From: Richard Castro-Parker
Sent: 23 September 2019 12:58
To: Daniel Vick
Subject: FW: BE/139/18/PL - Innovation Centre Beeding Close

From: Richard Castro-Parker
Sent: 23 September 2019 12:19
To: Laura Gibbons <Laura.Gibbons@arun.gov.uk>
Cc: Juan Baeza <Juan.Baeza@arun.gov.uk>; Samantha Lee [REDACTED]
Subject: FW: BE/139/18/PL - Innovation Centre Beeding Close

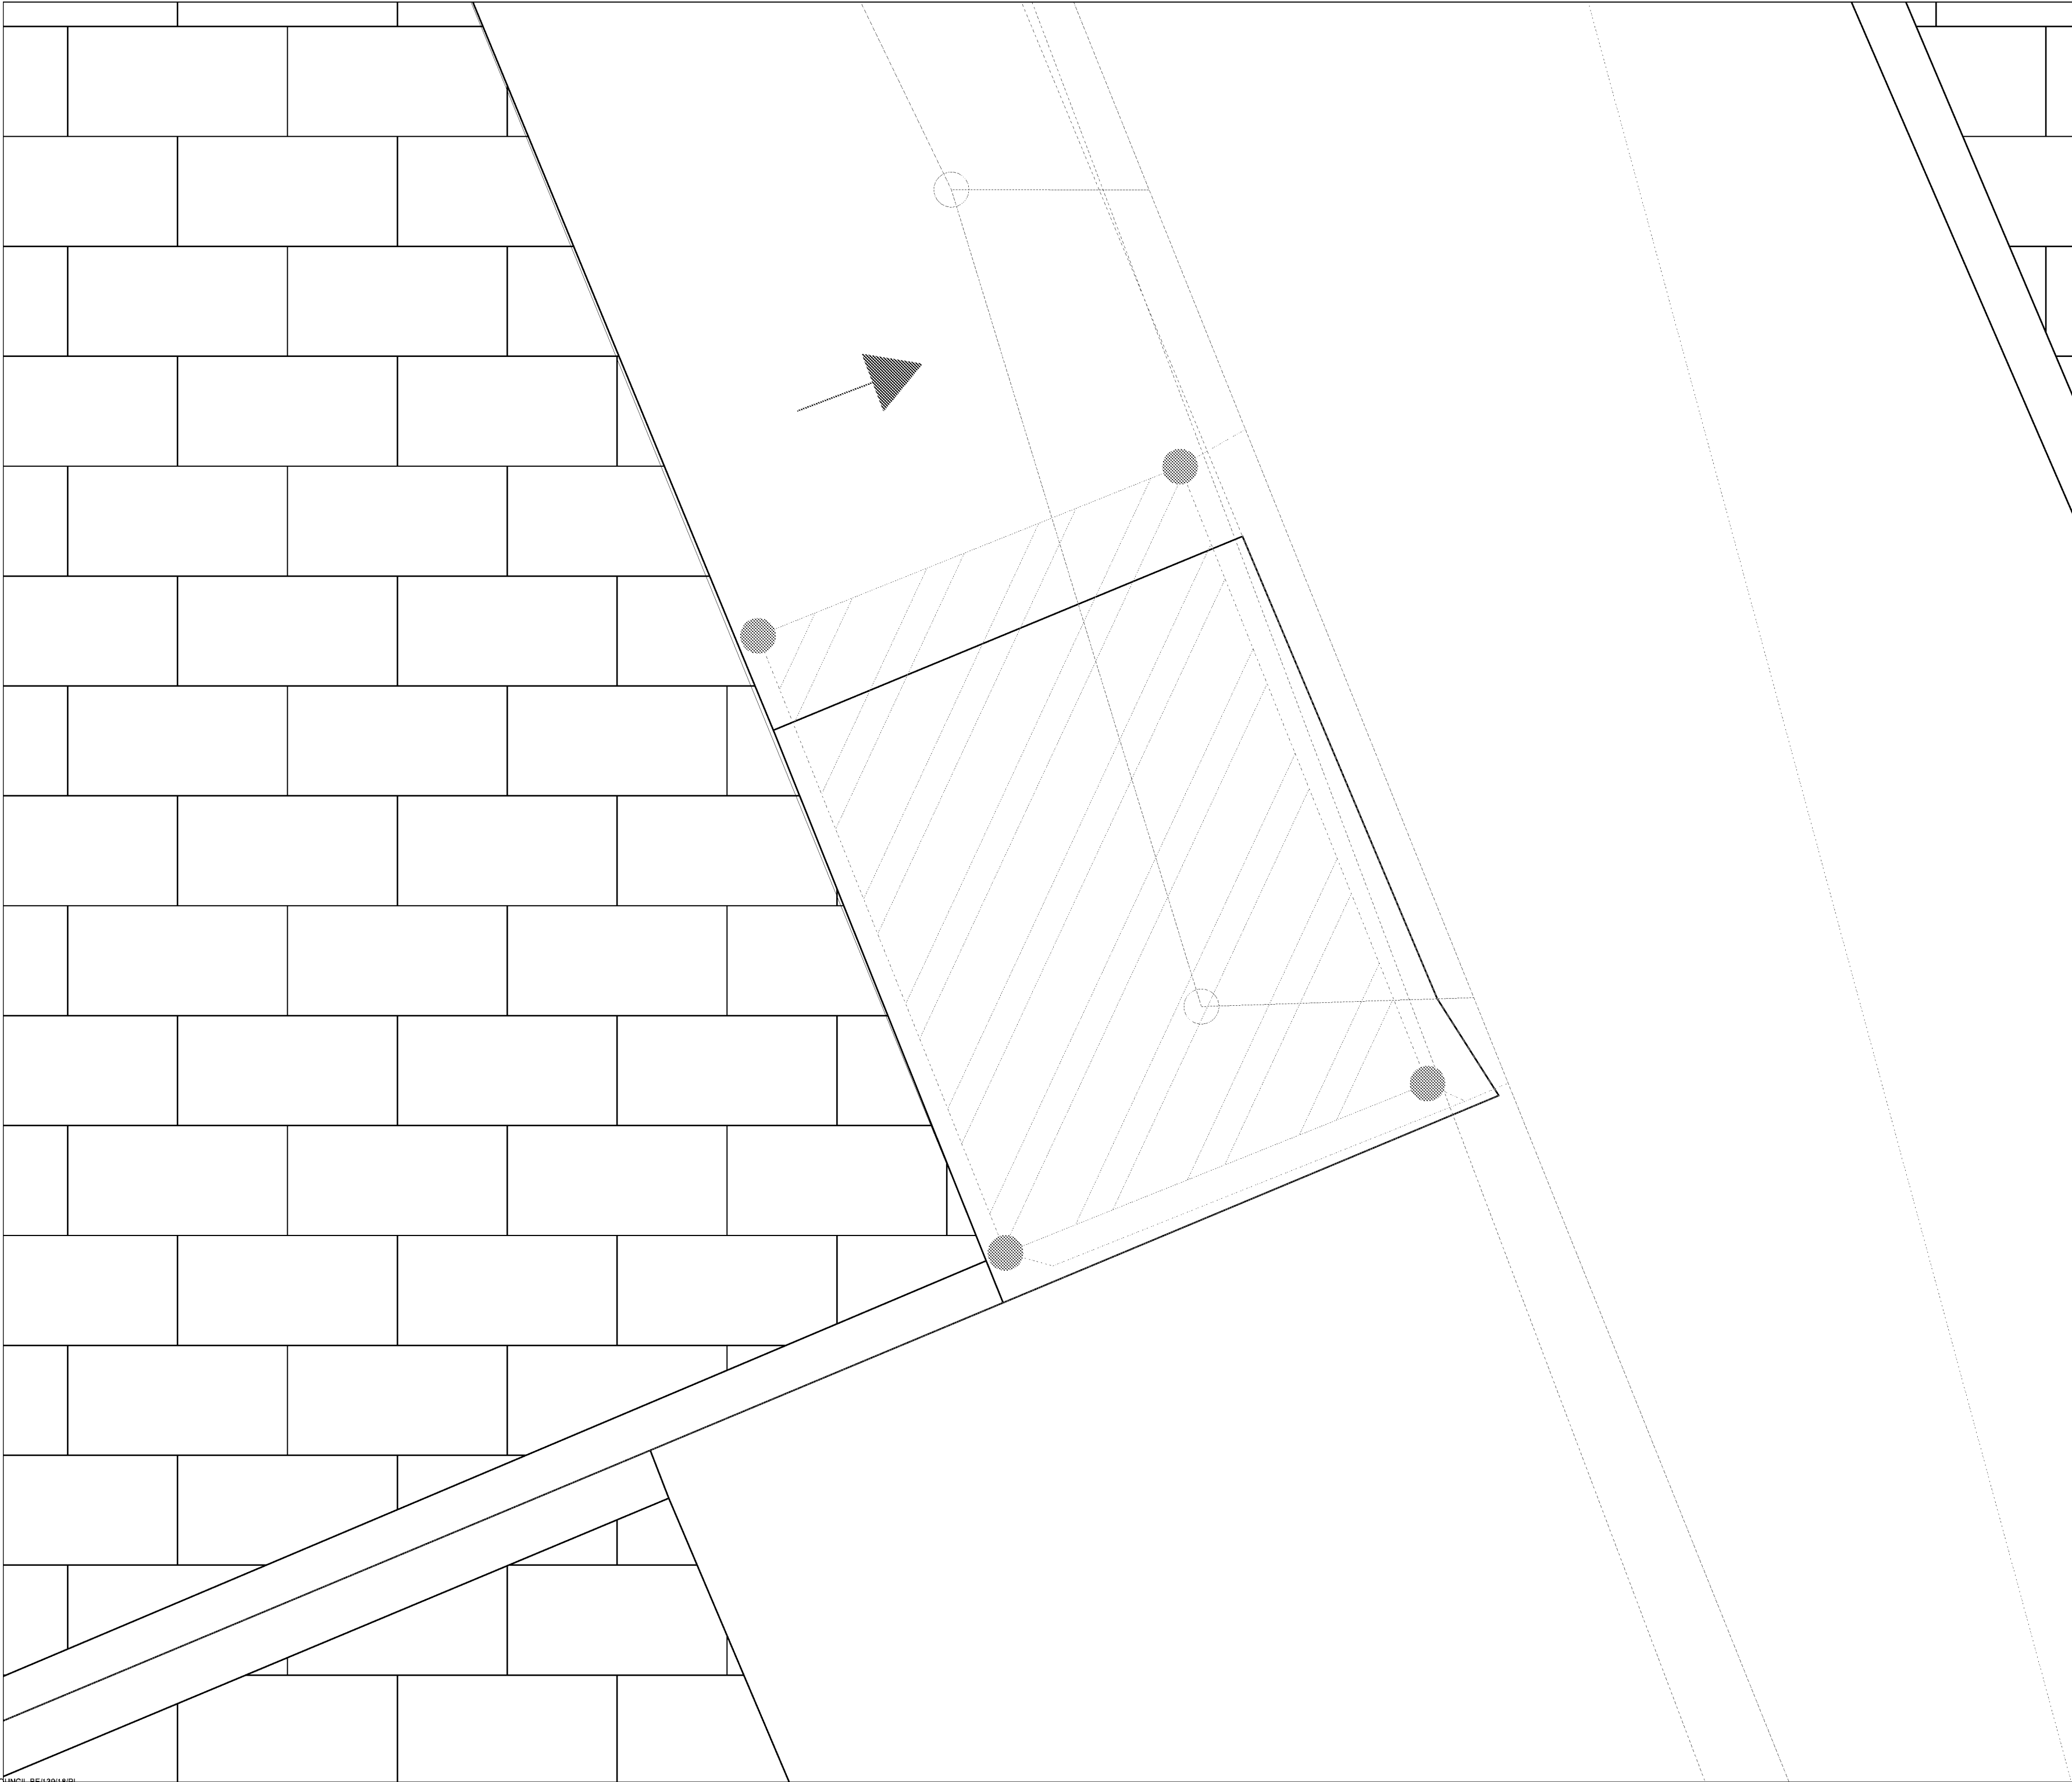
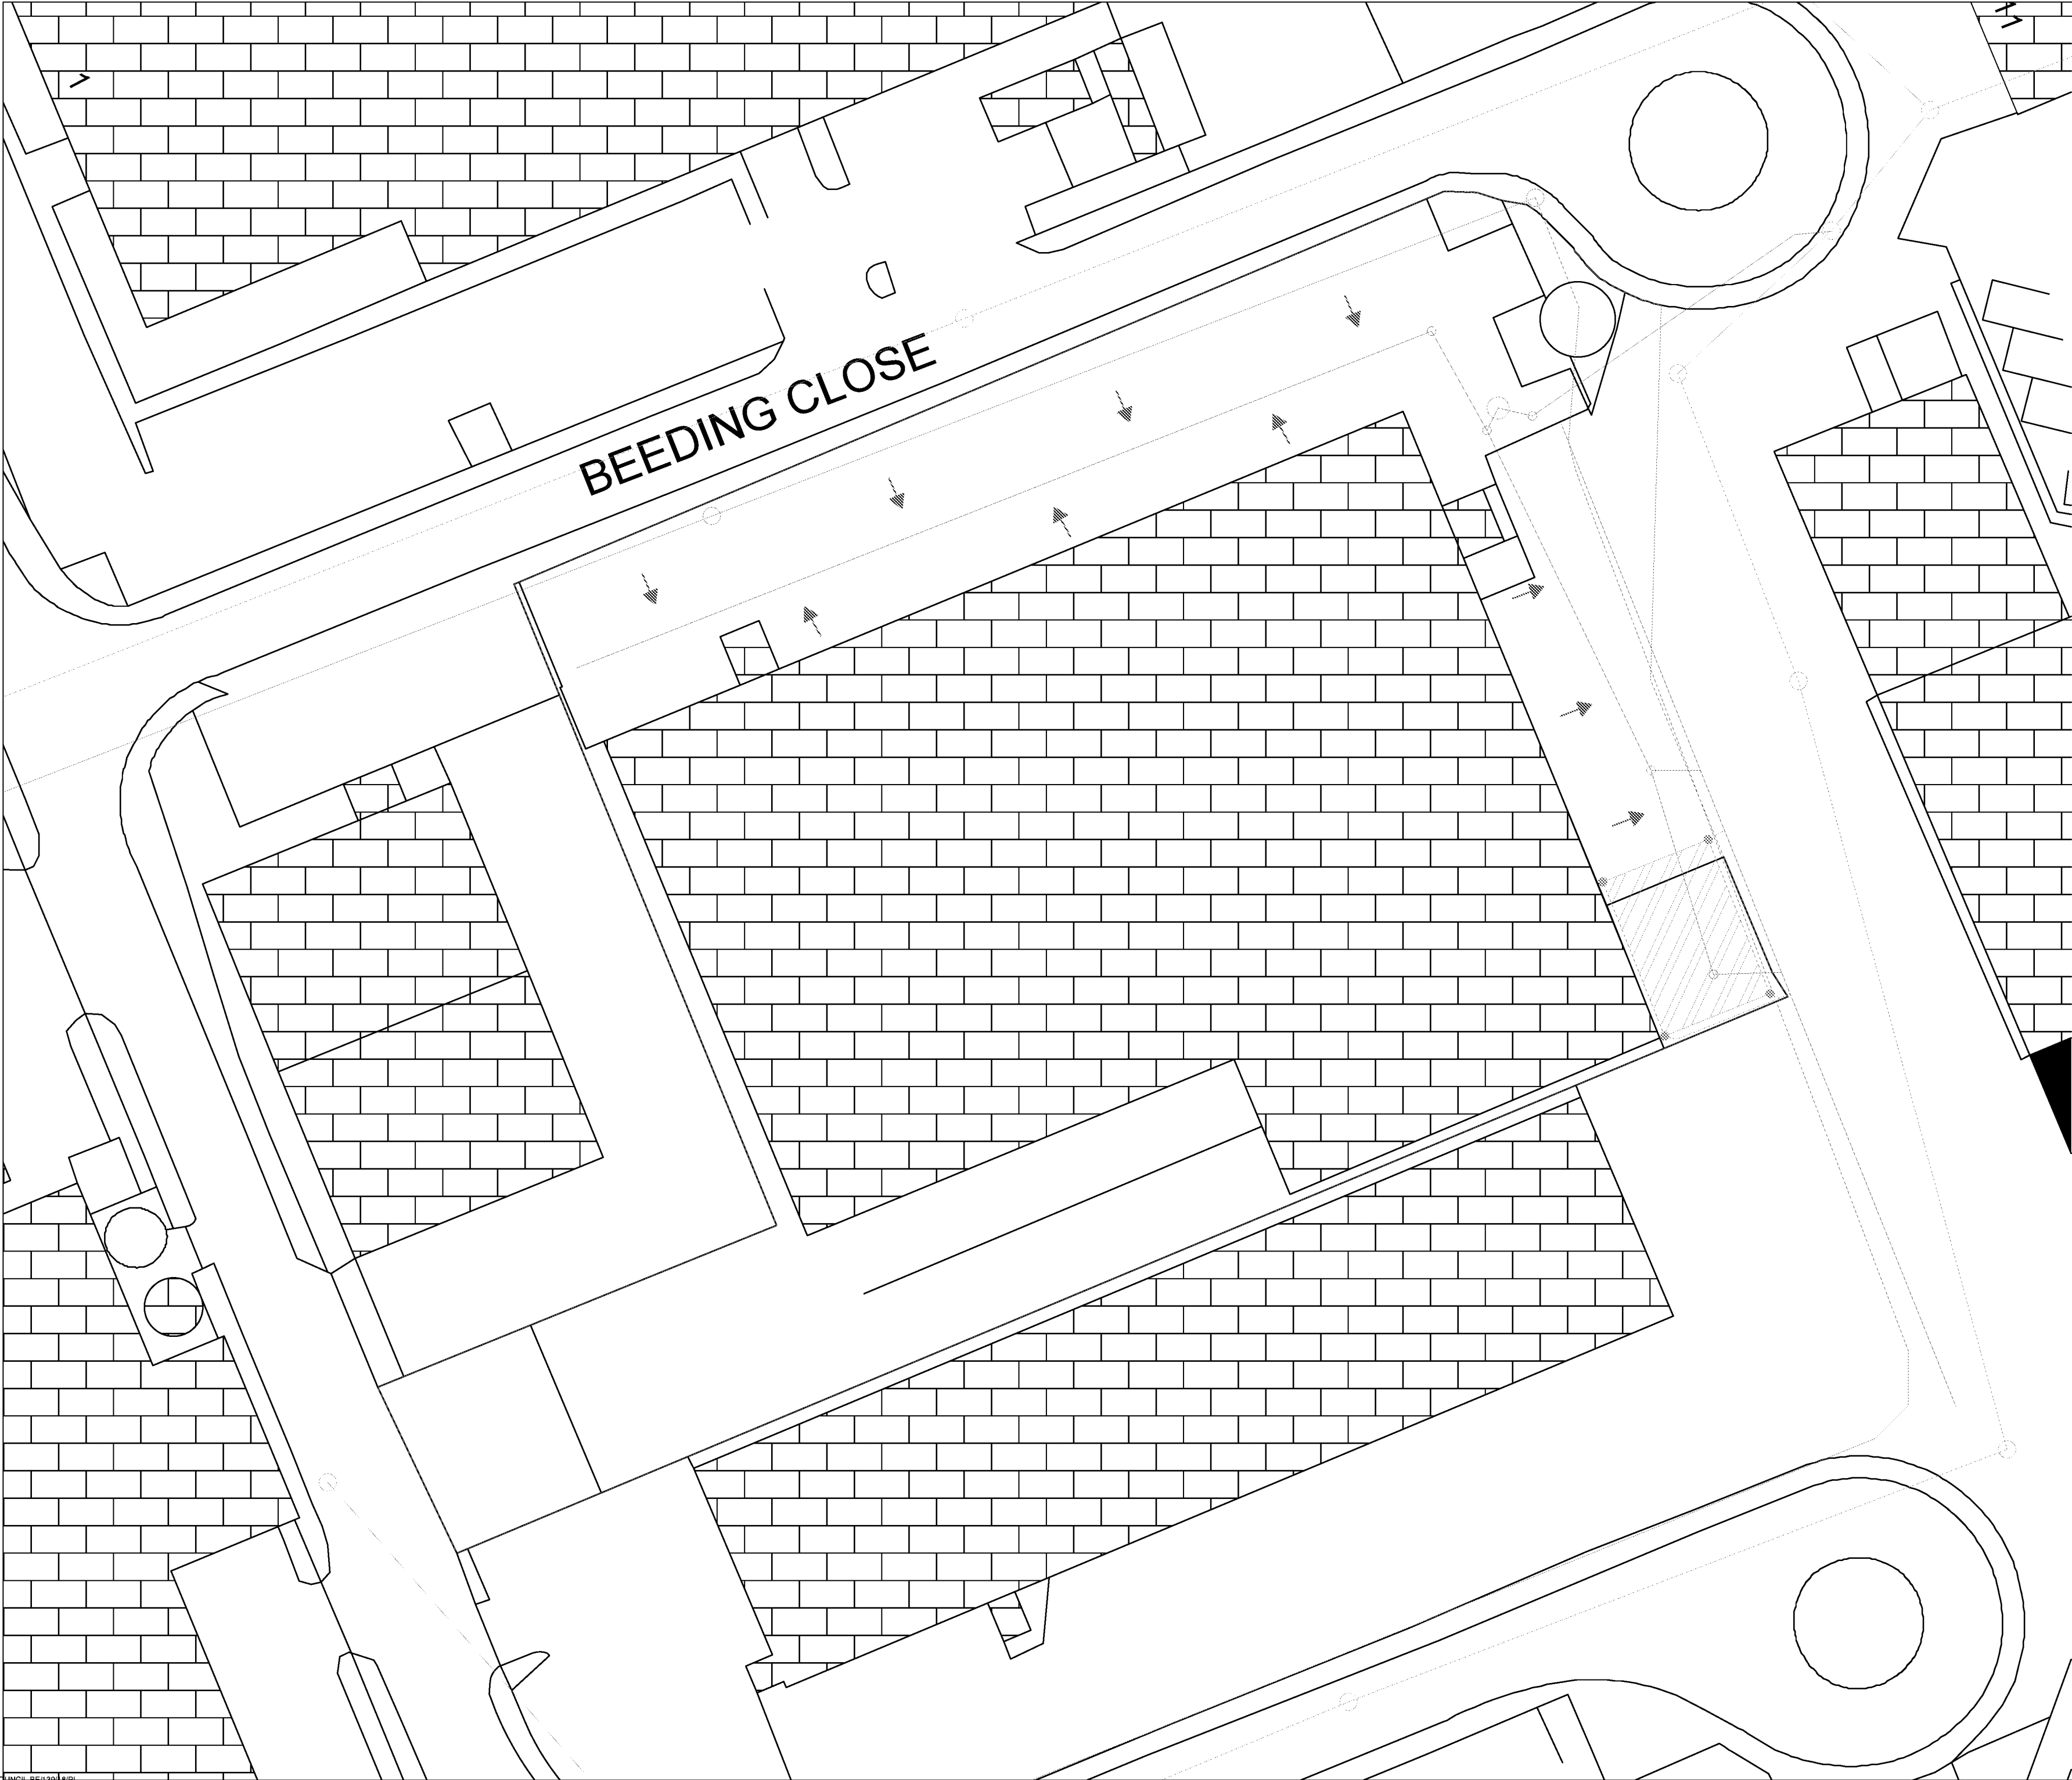
I still am struggling to distinguish between lines. Please can different line types be used, rather than all very similar colours. Please can gullies, manholes, and linear drainage channels be clearly labelled.

Regarding the levels, I also requested some spot levels of the surrounding land, can these be provided. This is fundamental to ensure that the surface water from the development does not go off site.

Please can the applicant submit clearer plans of the proposed surface water drainage arrangement. I.e. different line types used, rather than all very similar colours. Please can gullies, manholes, and linear drainage channels be clearly labelled.

I also require levels to be submitted showing invert and cover levels of the existing drainage network and spot levels of the surrounding land. This is fundamental to ensure that the surface water from the development does not go off site.

The colour of the lines have been changed and it is very different from each other in my screen. Please therefore let me know if Laura is still unable to distinguish them. I've also got confirmation from the client that they already have someone booked in to have the drainage cleaned.

Please find attached a PDF of the drainage layout plan for the site. Given the size of the site, all lines on the plans are small. However, if Laura zooms in she will be able to distinguish between the pipes types. This should hopefully address her first concern.

With regards to levels, having reviewed the sewer asset location search requested from Southern Water, both invert and cover levels for all Southern Water manholes are detailed within their response. A copy of the sewer asset location search was included within the appendix of the Surface Water Drainage Strategy -- this have been attached to this email for her reference.

Figure 1: LiDAR Elevation Map (Source: OS, EA)

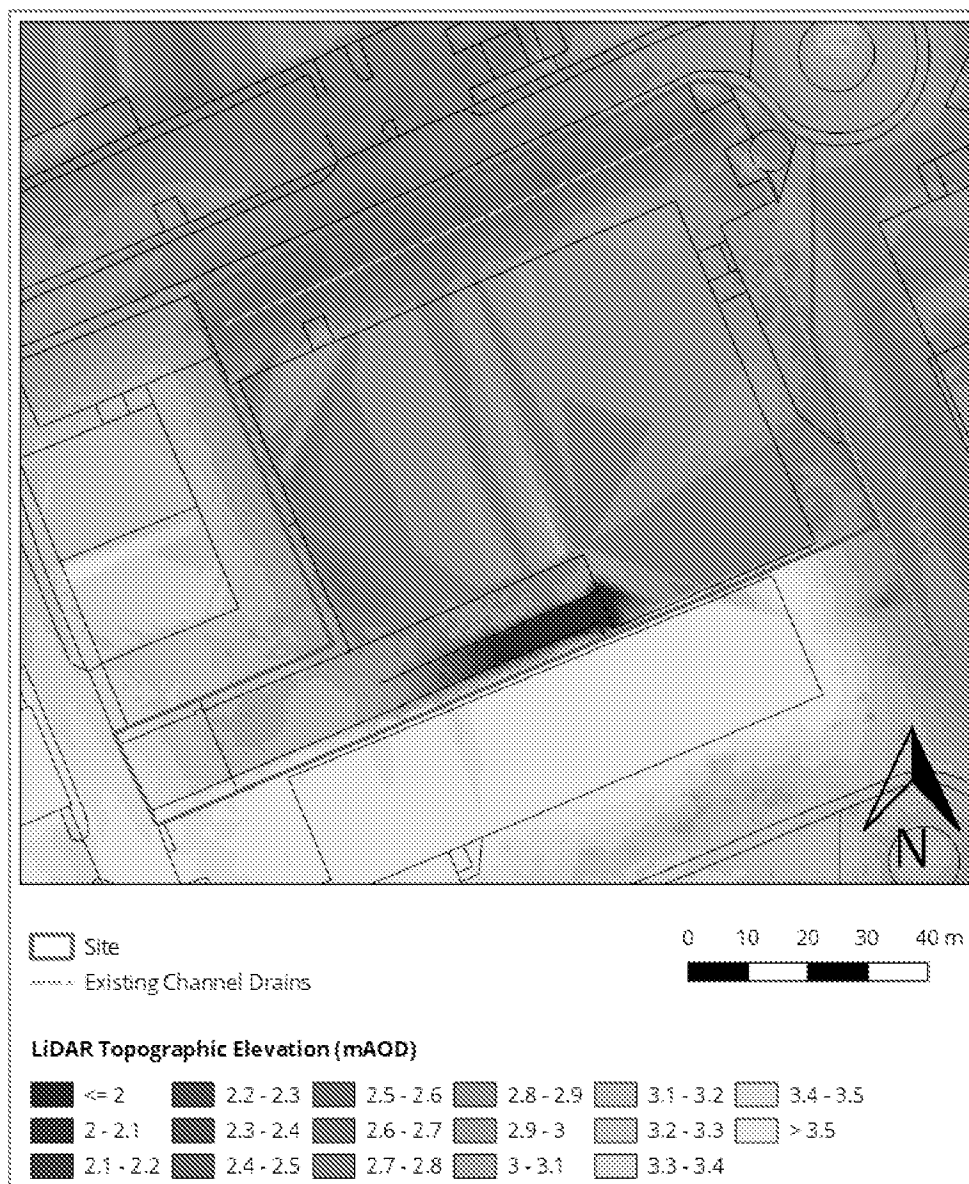
‘Regarding the applicants question as to potential use of LiDAR- LiDAR could be used if it is demonstrated that there is a good correlation between LiDAR levels and the known cover level of the manhole. It may be that the LiDAR elevations aren’t particularly accurate due to building shadow effects.’

With regard to spot levels, could Laura ascertain whether the Environment Agency LiDAR information would be sufficient information to determine the rough elevation of the surrounding land? Unfortunately, our flood consultant is not qualified to undertake a topographical survey of the surrounding land. We will therefore have to appoint a surveyor separately just to do the full survey for the displacement of 150sq.m of roof water.
